**KIRKLEES METROPOLITAN COUNCIL
INVESTMENT & REGENERATION SERVICE**

DELEGATED DECISION TO DETERMINE PLANNING APPLICATIONS

Reference No:	2024/62/92371/W
Site Address:	7, Haughs Green, Pike Law Road, Scapegoat Hill, Huddersfield, HD7 4NF
Description:	Erection of front and side extensions with alterations to roof and associated works
Recommending Officer:	Laura Yeadon

DECISION – CONDITIONAL FULL PERMISSION

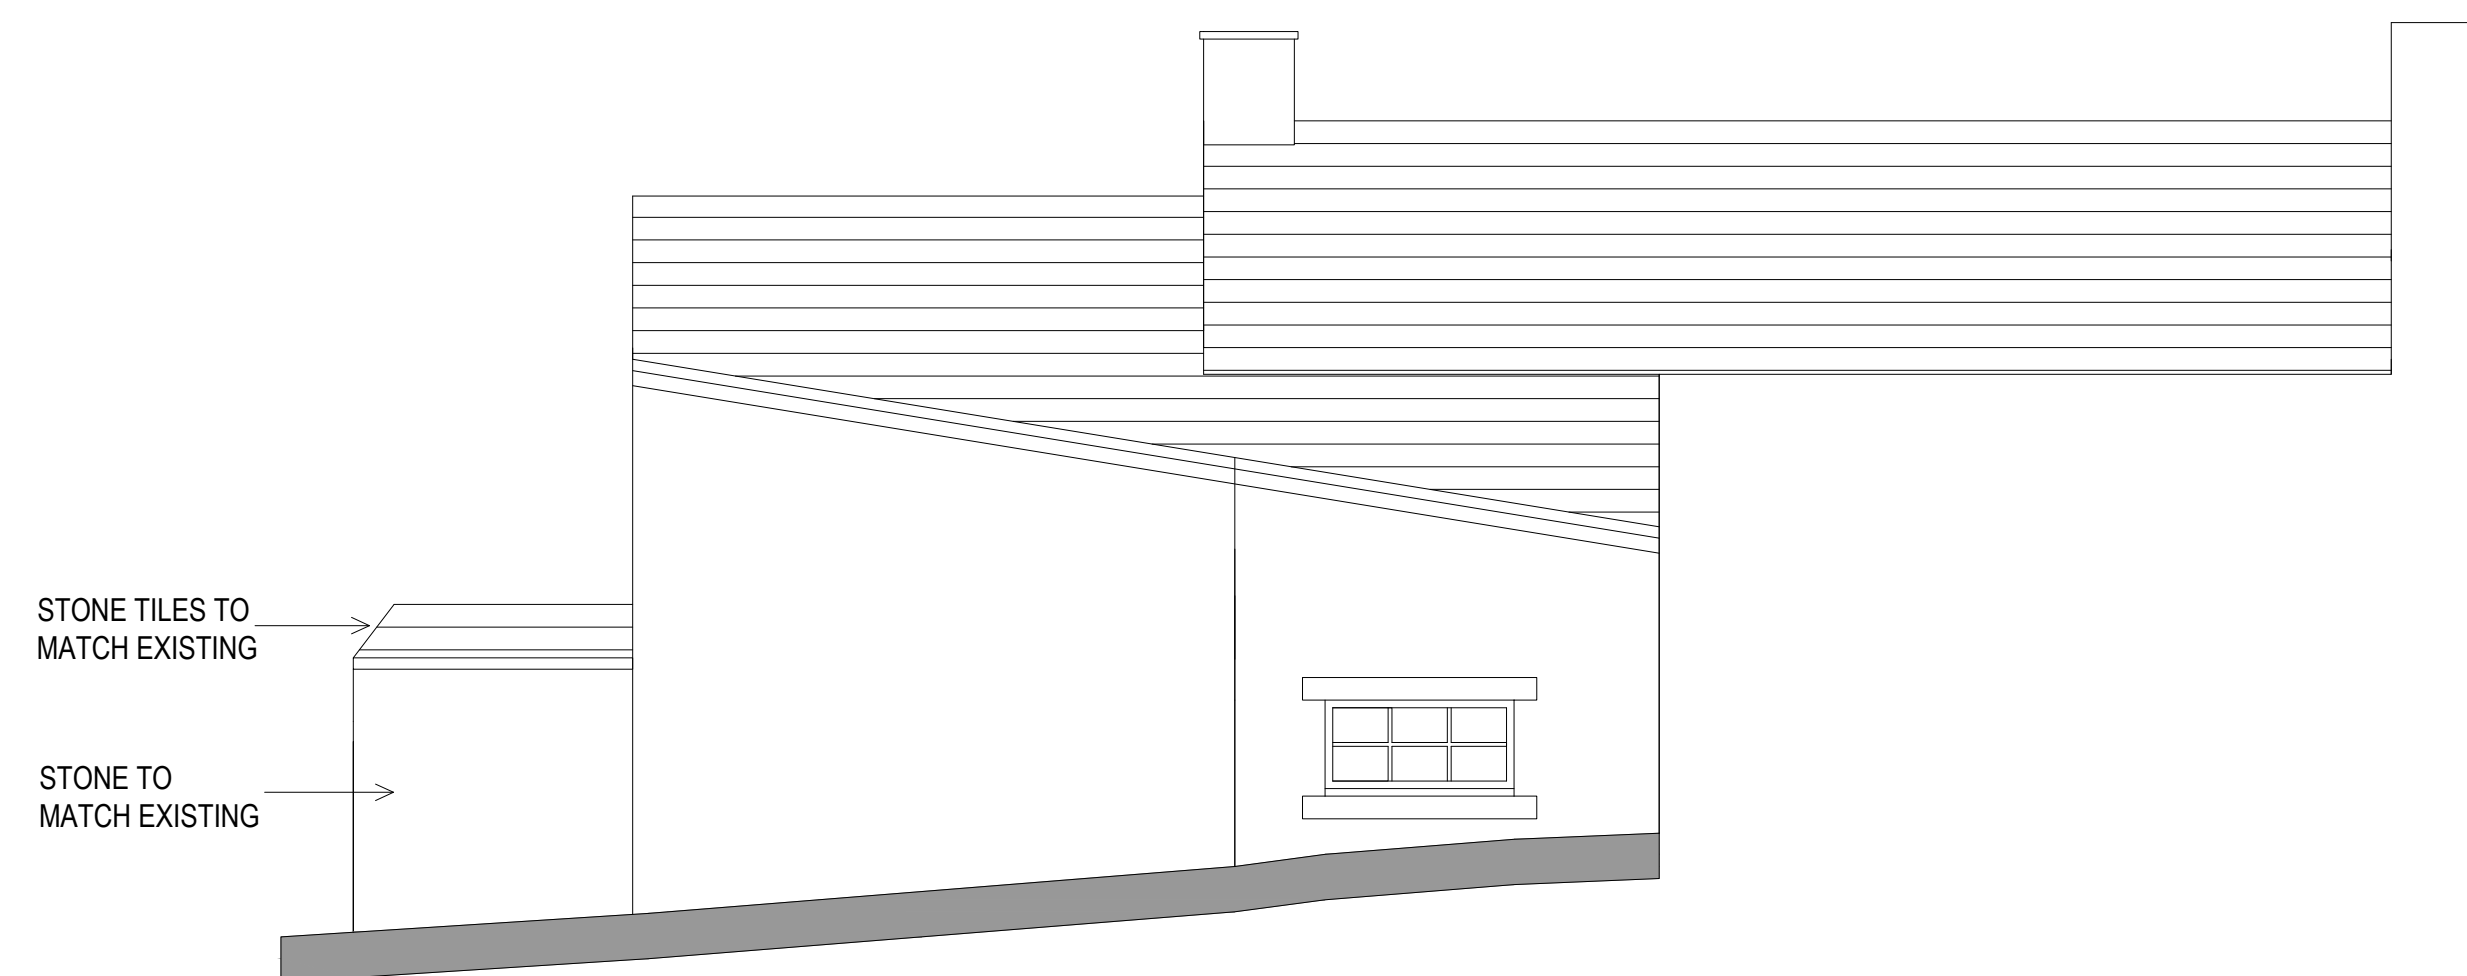
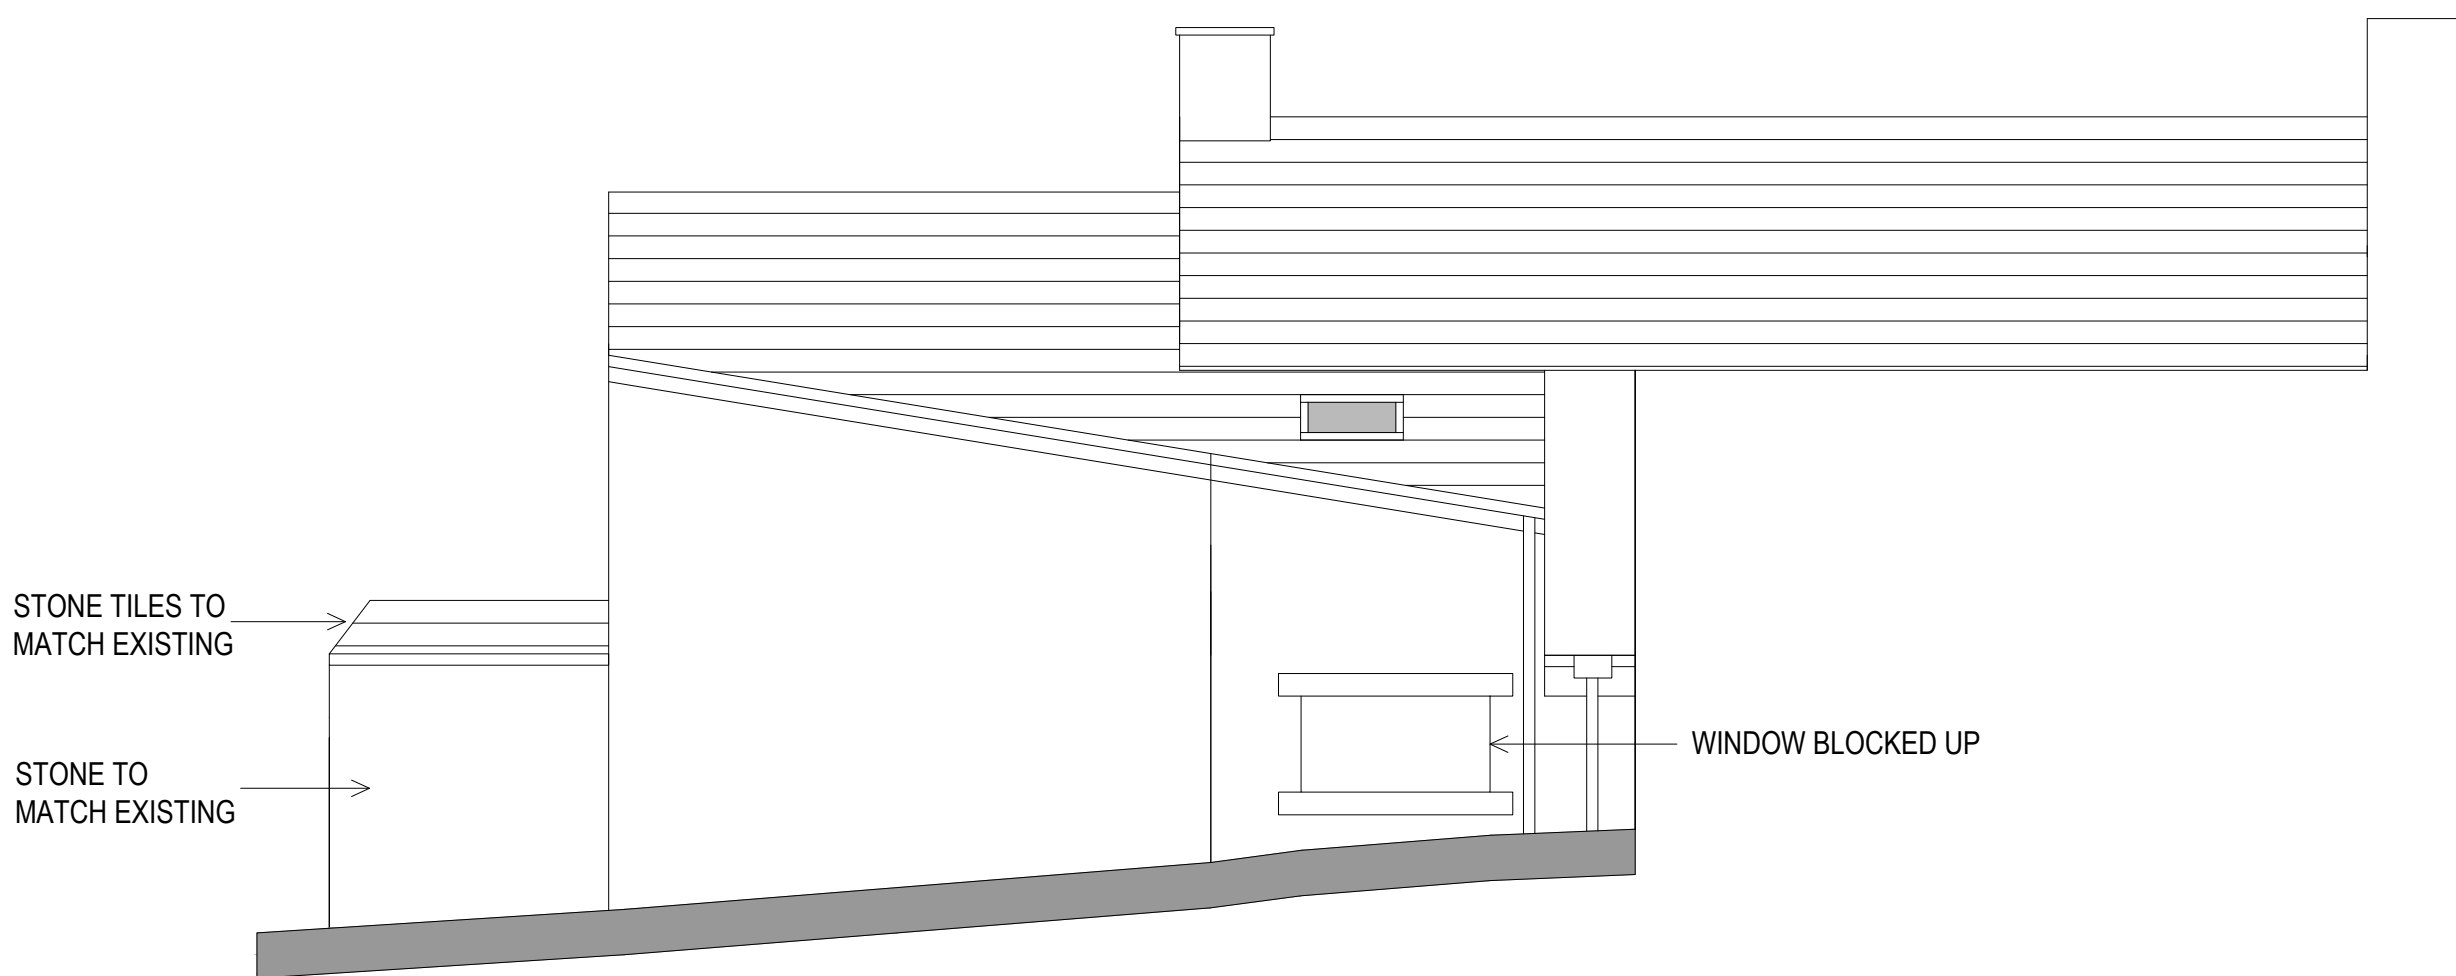
It was requested that the window arrangement within the south facing first floor elevation of the extension were amended from large, glazed openings to mullion windows to reflect the openings within the existing property. Amended plans have been received with the window arrangement altered and were received on 21st October 2024. Due to the alterations being solely to one bank of windows, it was not considered necessary to re-advertise the proposal.

It was requested that the window arrangement within the south facing first floor elevation of the extension were amended from large, glazed openings to mullion windows to reflect the openings within the existing property. Amended plans have been received with the window arrangement altered and were received on 21st October 2024.

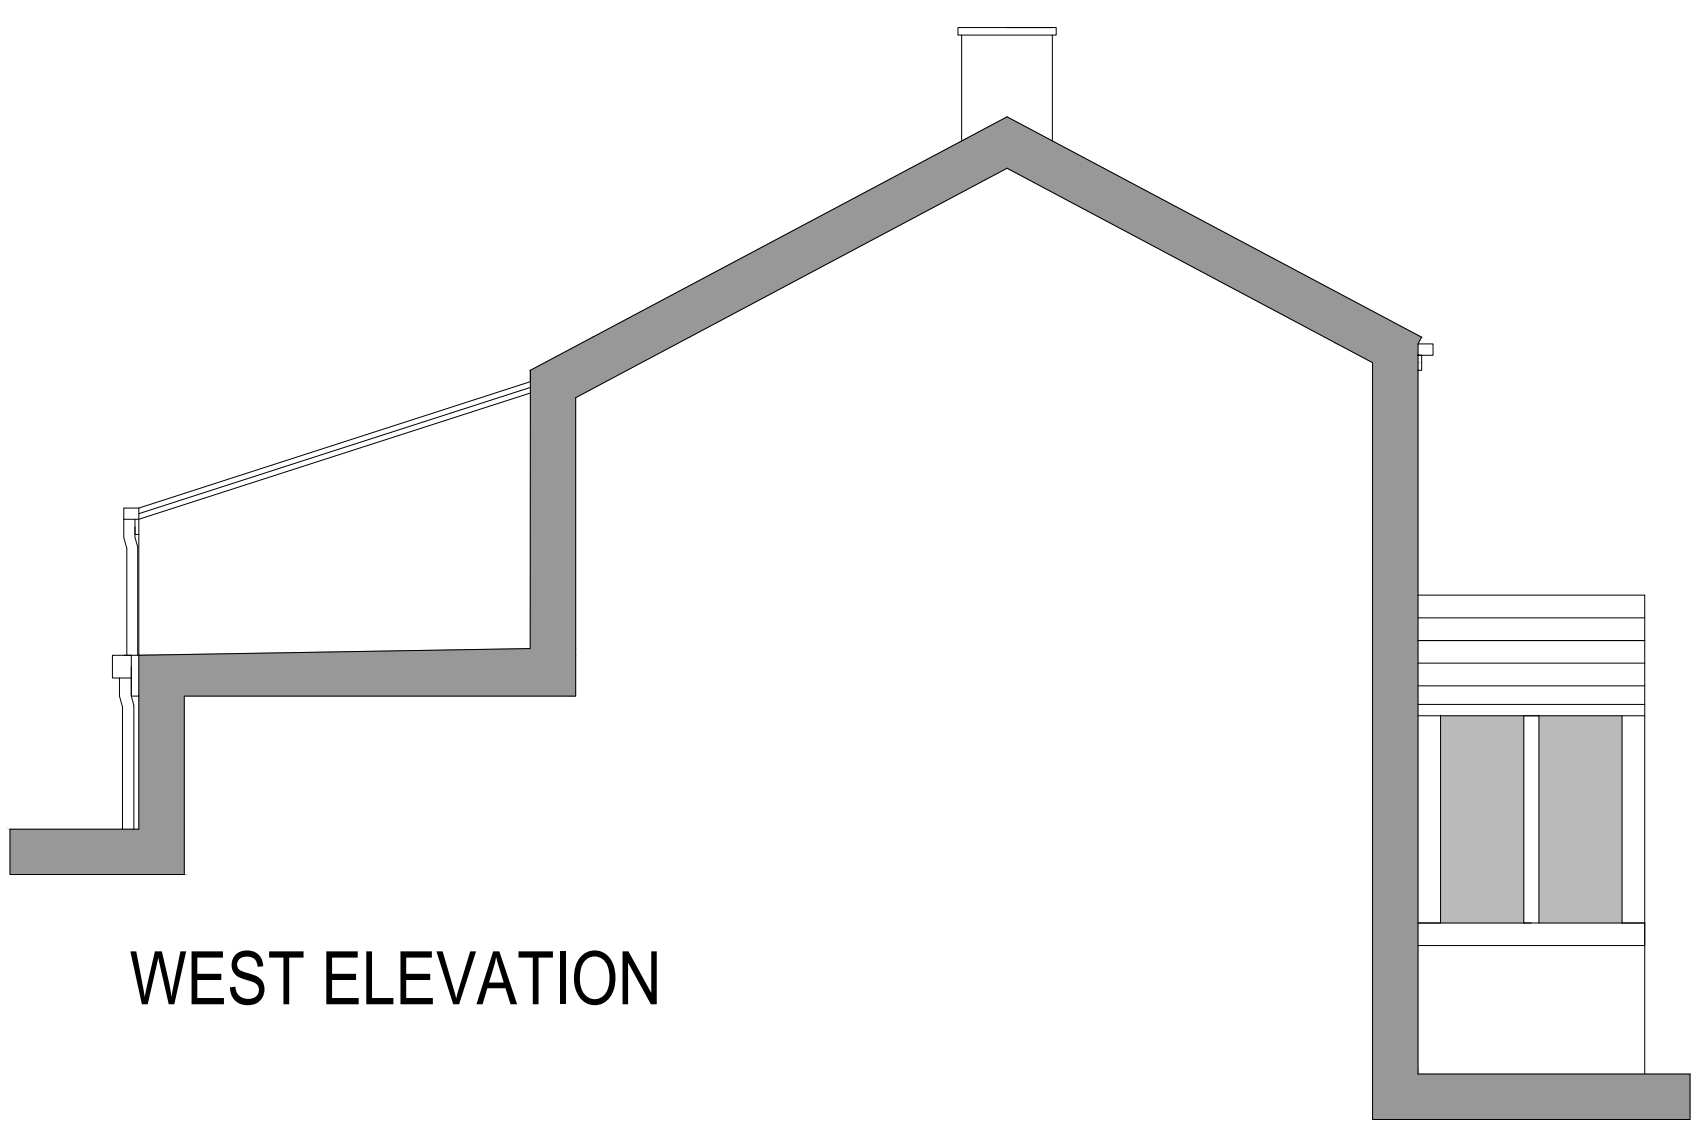
With regards to the impact on the attached neighbouring property, initial concerns were raised that the window within the north-west elevation of the property which is to the neighbouring dwelling would be lost as a result of the proposed roof works. During the course of the application, information was submitted which confirmed that the neighbouring property would have a rooflight installed as part of the proposed works. The amended plans which sought to amend the window details have incorporated this roof light and therefore, subject to an appropriate condition, this roof light shall be provided within the roof slope of the neighbouring property prior to works within the application site commencing.

4. Prior to the commencement of works within the application site, a rooflight shall be provided in the north elevation roof slope of No. 9 Haughs Green as shown on drawing number 2356 – 02 – B.
